East Anglia ONE North and East Anglia TWO Offshore Windfarms

Applicants' Responses to Examining Authority's Written Questions

Volume 18 – 1.18 Transportation and Traffic

Applicants: East Anglia ONE North Limited and East Anglia TWO Limited
Document Reference: ExA.WQ-1.D1.V1_18
SPR Reference: EA1N_EA2-DWF-ENV-REP-IBR-001085 Rev 01

Diagram of Traffic Movements Assigned to the Highway Network

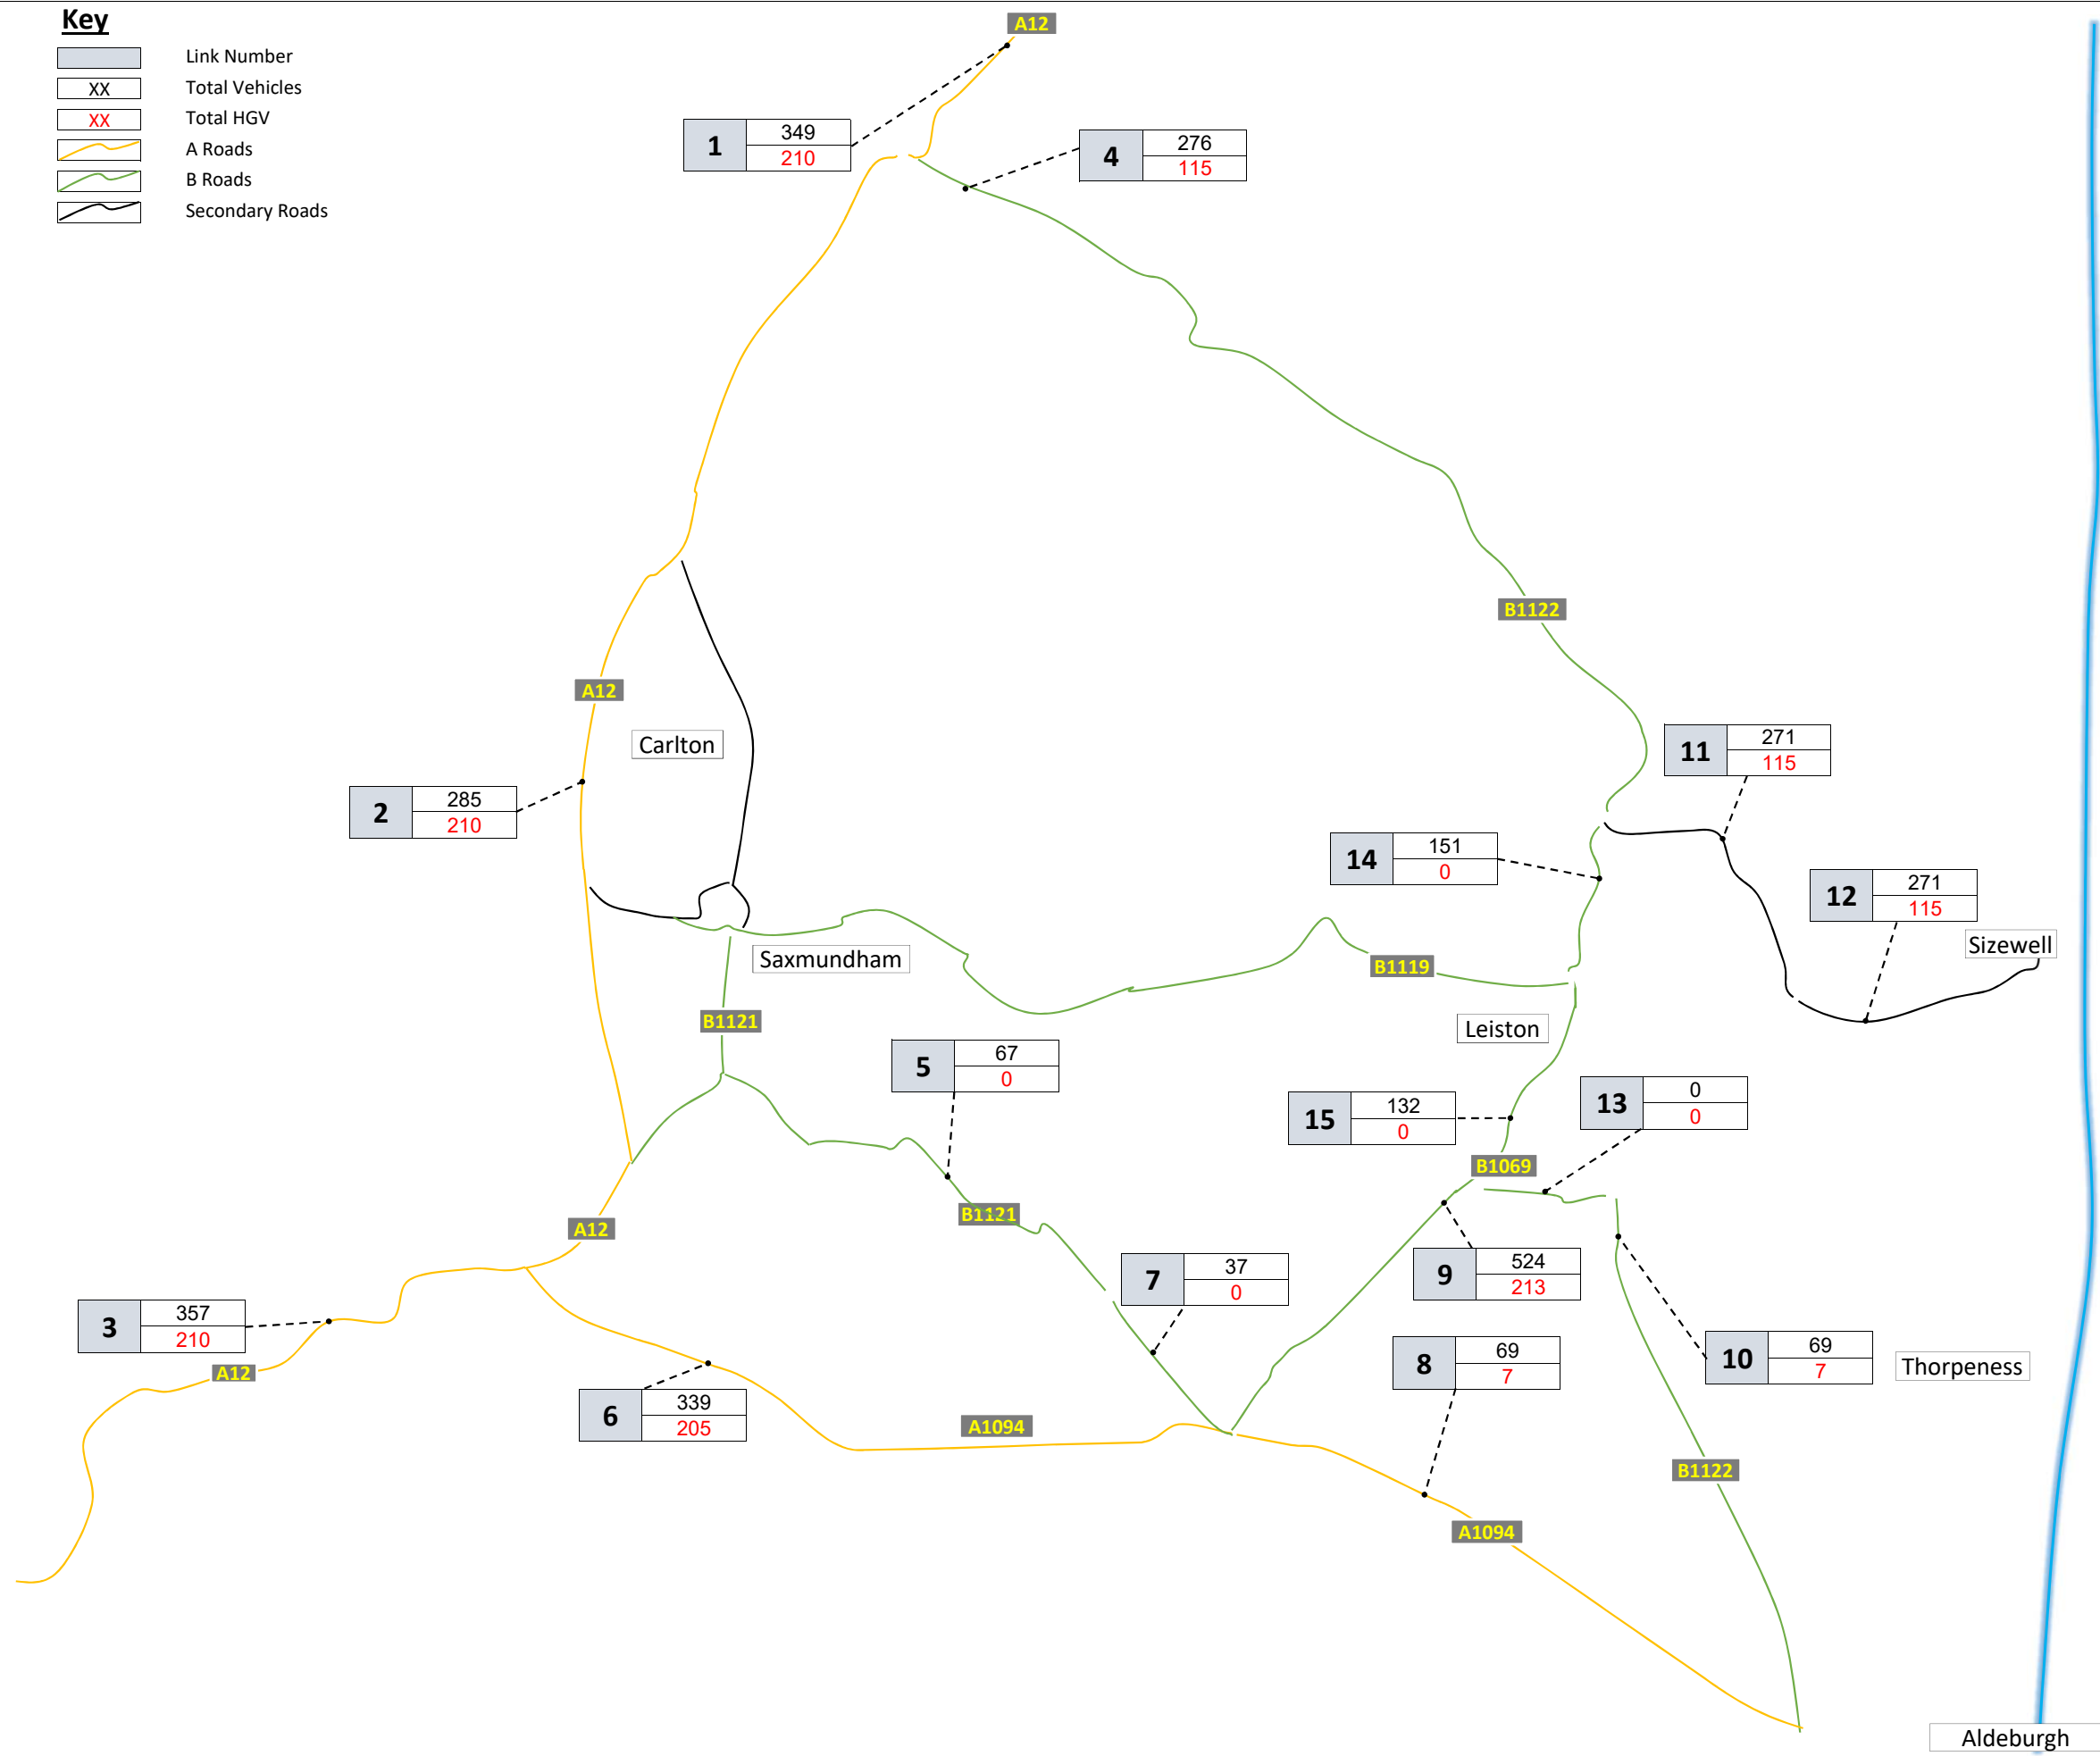
ExA. Question Ref.	Question addressed to	ExA. Question		Applicants' Response
1.18.13	The Applicant	1	2	<p>Appendix 26.16 [APP-542] is titled "Traffic Movements Assigned to the Highway Network".</p> <p>Please confirm that these are total numbers of construction related vehicles and state the time period(s) to which they relate, eg peak hour, 12-hour, AADT.</p> <p>Paragraph 216 of Chapter 26 of the ES (APP-074) confirms that Appendix 26.16 (APP-542) details the assigned total daily peak two-way vehicle movements (i.e. arrivals and departures) of all materials, personnel and plant during the peak combined month when distributed across the highway network.</p>
